We write on behalf of Mr James March-Smith ("our client") in respect of an application by Highways England for an Order Granting Development Consent for the A303 Sparkford to Ilchester Dualling (Ref. TR010036).

**A303 SPARKFORD TO ILCHESTER DUALLING SCHEME – RESPONSE TO QUESTIONS FROM THE EXAMINING AUTHORITY**

We act for Mr James March-Smith ("our client") the freehold owner of Sparkford Hall, Sparkford, Yeovil, BA22 7LD ("the Hall").

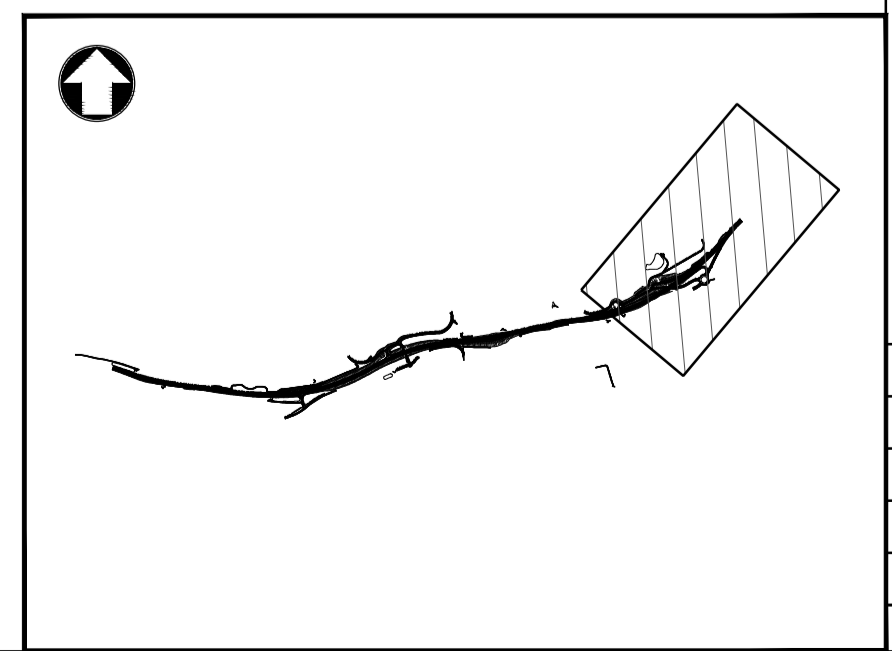
- An extension of the proposed new road noise reducing surface along the Hall's eastward boundary to Chapel Cross.
- In relation to mitigating the impact from lights caused by the scheme, the bund referred to above would also provide some shielding from the effects of traffic headlights along the scheme's proposed elevated road.

- Consideration be given to the proposed lighting strategy so as to reduce the Hall's exposure to artificial lighting during construction.
